CITY OF ALBUQUERQUE

RE: **Palomino Roofing** – 6910 Huseman Drive SW
Request for **Permanent** C.O. – **Denied**
Engineer's Stamp Dated: 05-09-2007
Certification Dated: 11-04-13

M10/D016F

GRADING AND DRAINAGE PLAN
 PALOMINO ROOFING CO.
 6910 HUSEMAN DRIVE

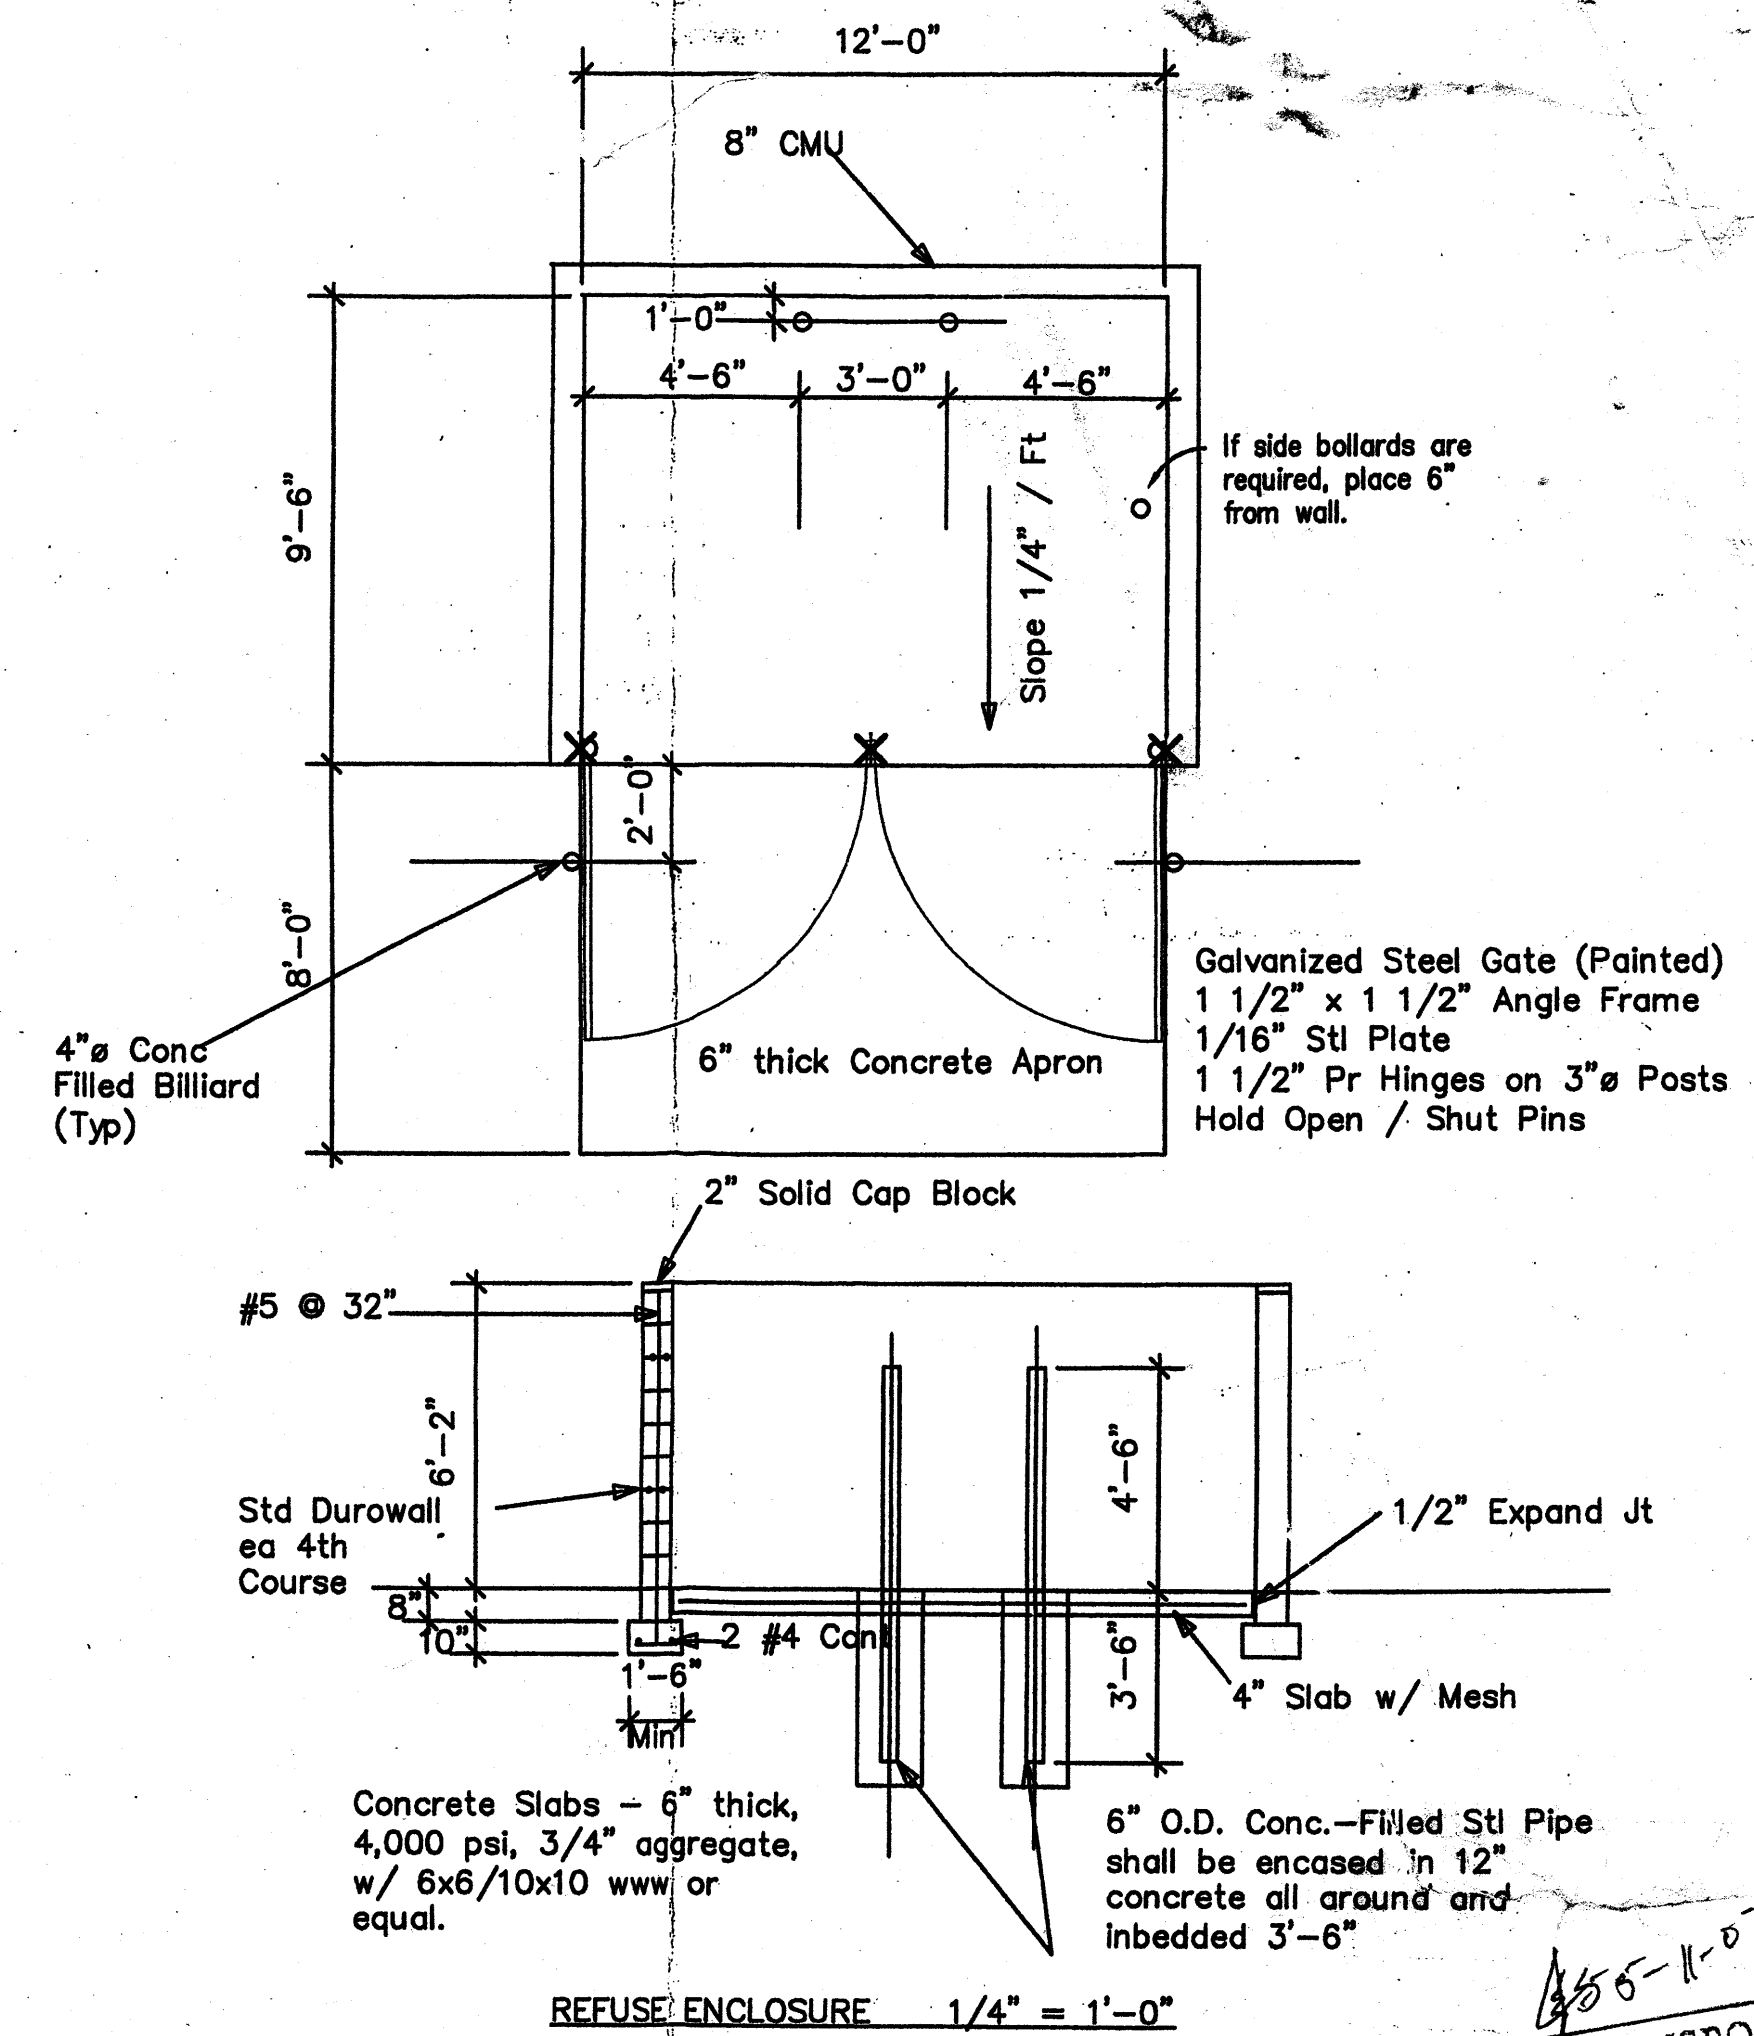
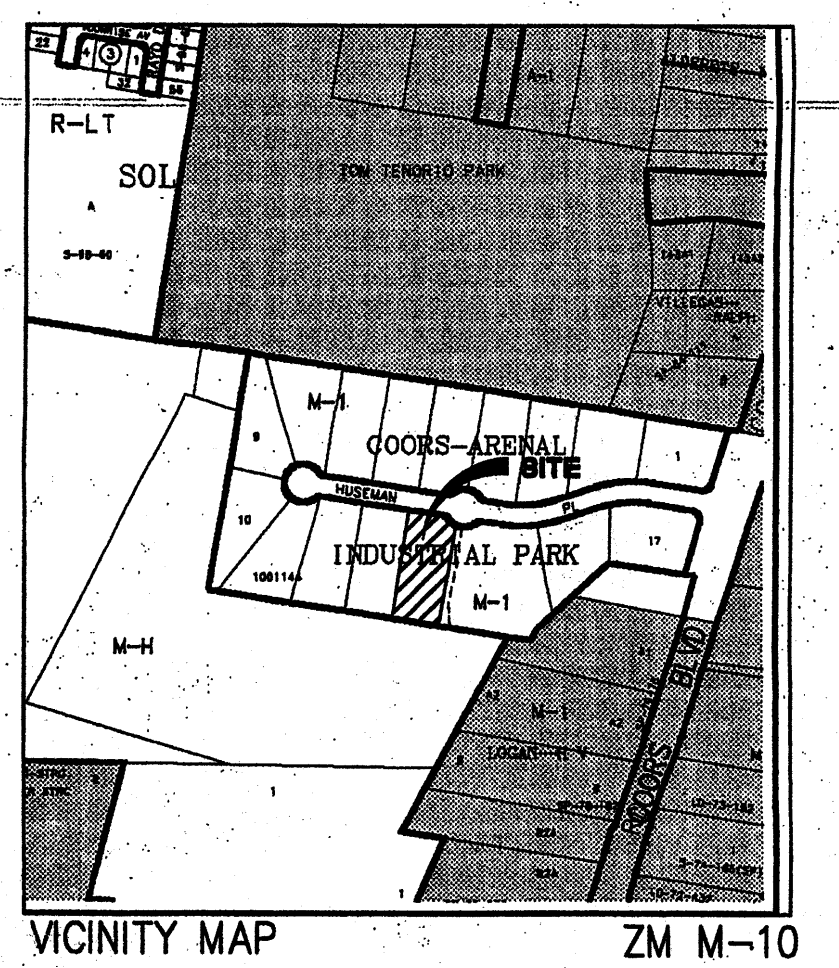
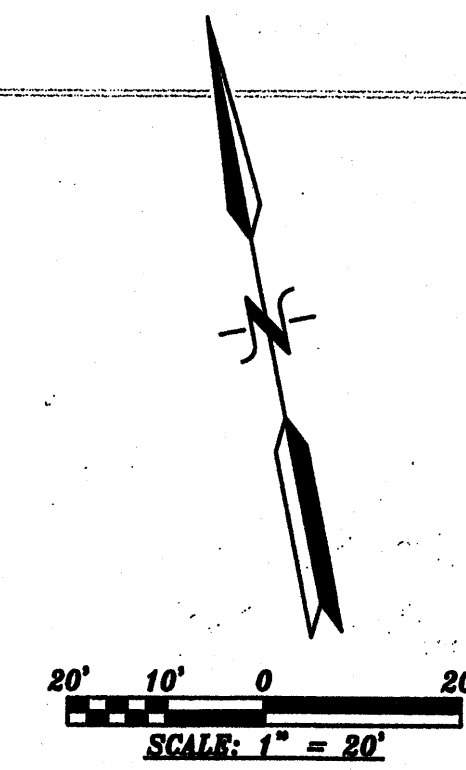
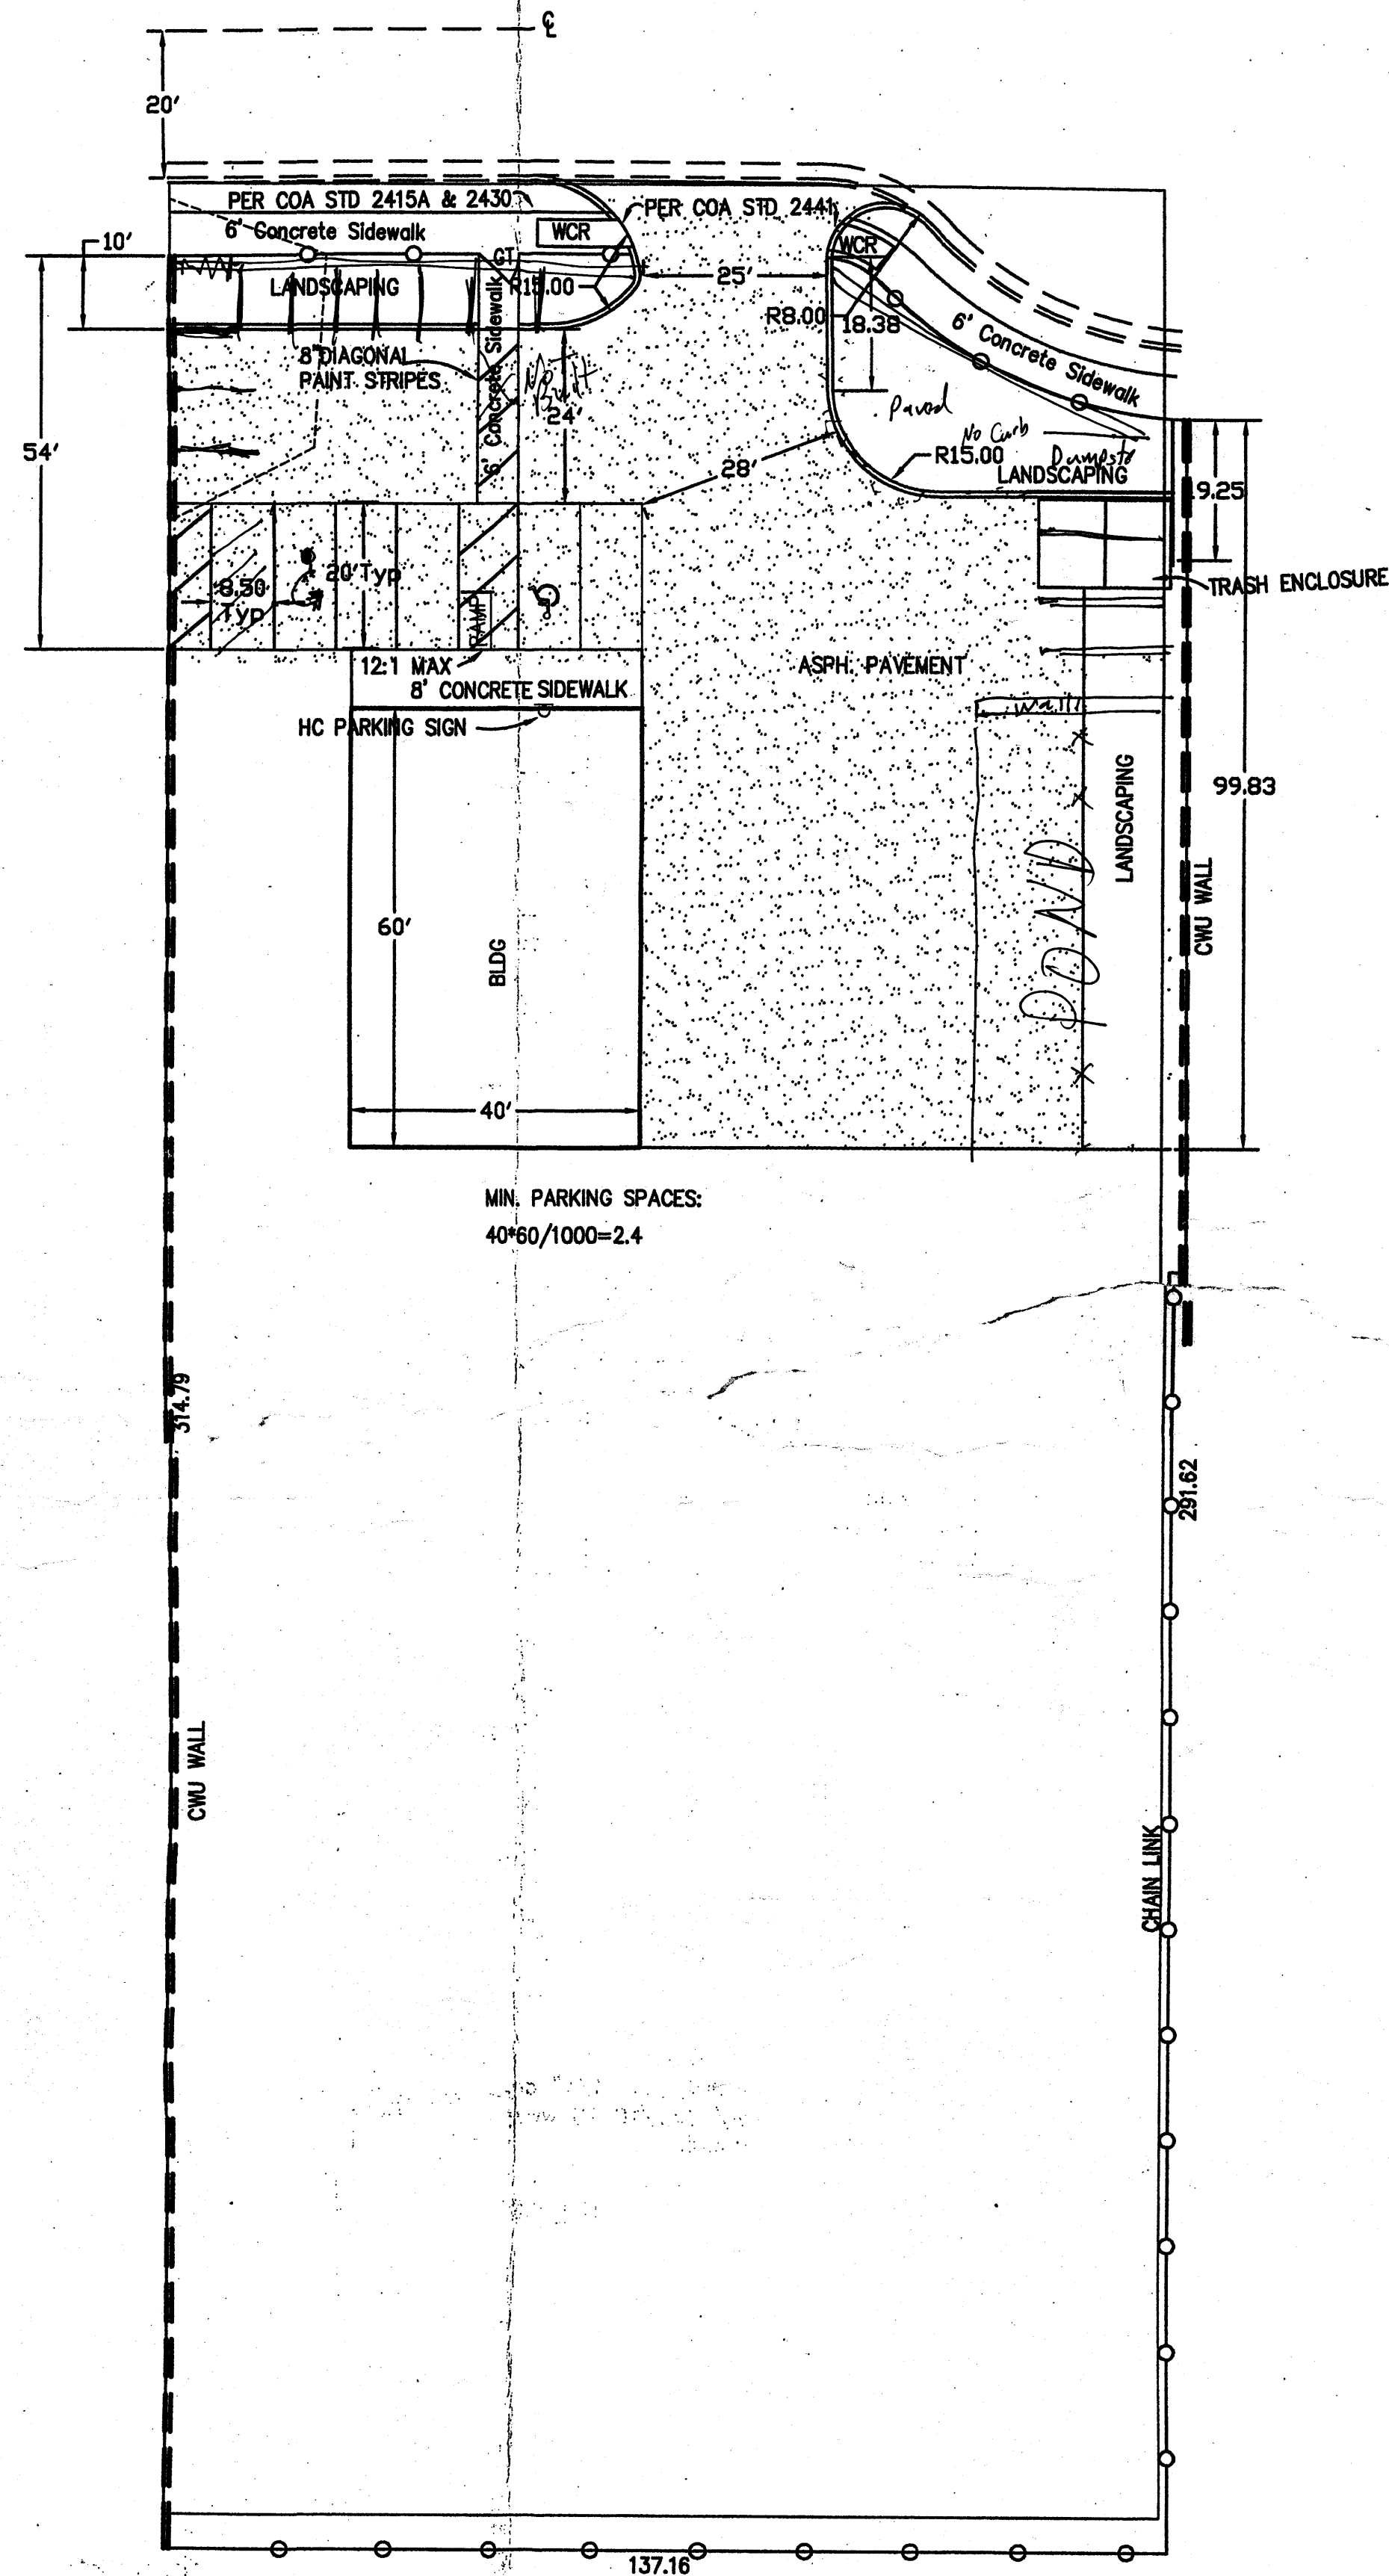
1. The small pond in the NE quadrant of the site is not adequate to provide the calculated, 10-day storm volume required for this developed condition.
2. Based upon aerial photos, it appears that the southern portion of the site is being used as a construction yard, and has been compacted by use to the point of increasing runoff, to a type "C" treatment. This plan inaccurately indicates the area to be "UNDISTURBED." Developed runoff calculations should be revised, if different from the design flows.

3. As-built Pond Volume calculations appear to be based upon the "Water Surface" contour at elevation 83.8 and a pond bottom of 81.77. However, grades shown indicate that the eastern boundary of the pond is part CMU wall and part chain-link fencing, with ground elevations below 83.8. Clarify who the site will retain the required 10-day runoff volume.

4. There appears to be CMU wall along the entire east and south property lines. This plan should indicate as-built conditions, and clarify whether or not the CMU has openings, or if it will retain water.

5. As-built Drainage Certification language needs to include who provided the as-built survey information. Attached below is a copy of the typical, Drainage Certification language that we prefer to see.
